A303 Amesbury to Berwick Down

TR010025

8.10.3 Air quality and emissions (AQ.1)

Air quality and emissions (AQ.1)

Drawing file: published-documents / TR010025-000216-6-2_ES-Figure_5.2_AQ_Baseline.pdf

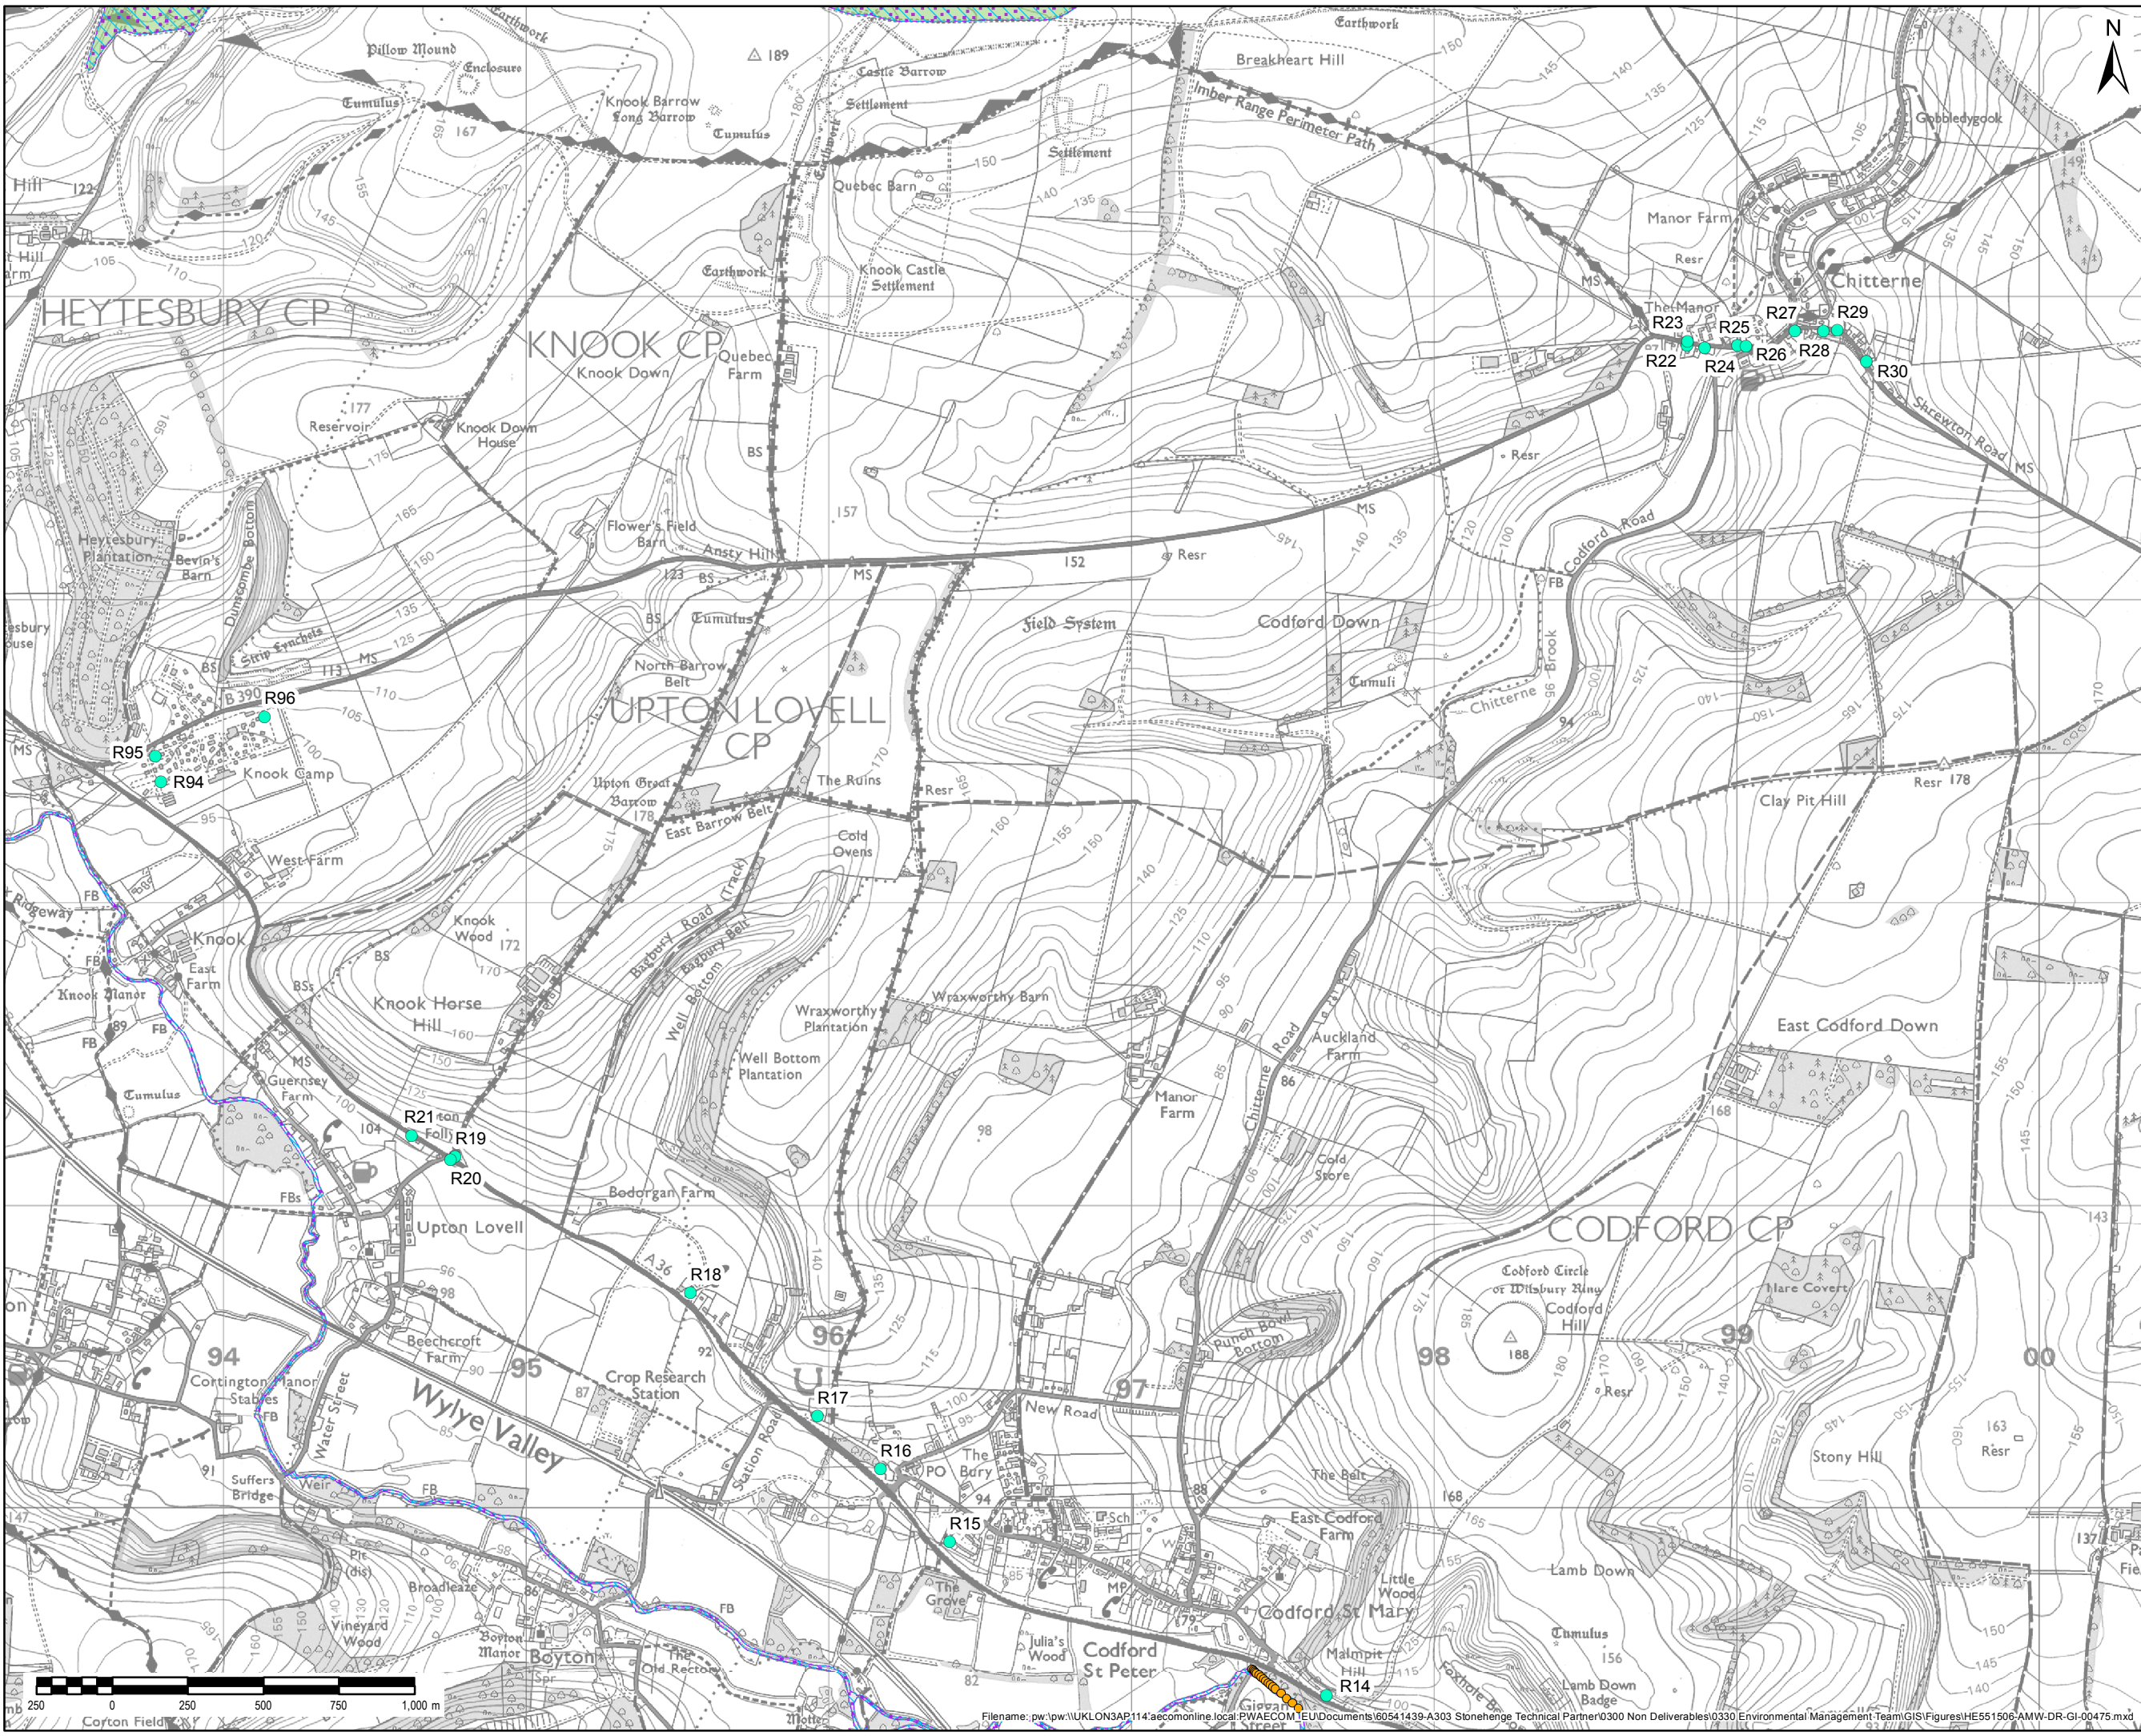
Can the Applicant state why only 15 of the 32 diffusion tube receptor locations have been included within [APP-063] Figure 5.2?

1. Highways England deployed 32 diffusion tubes in the area local to the Proposed Scheme to provide a range of information on general baseline conditions (i.e. concentrations close to roads) and background conditions (i.e. concentrations away from roads).

2. Figure 5.2 [APP-063] focused on the baseline conditions from the key subset of diffusion tubes that were utilised in the model verification process and in the local air quality assessment rather than all background and baseline diffusion tubes.

3. The details of all diffusion tube locations, along with grid references, are provided in the ES [APP-190] Table 5.1.1.
4. As is typical in diffusion tube surveys not all diffusion tube sites are used in the model verification process. A list of the diffusion tubes not included in the model verification process and the reason for excluding the tubes in numerical order are presented below:
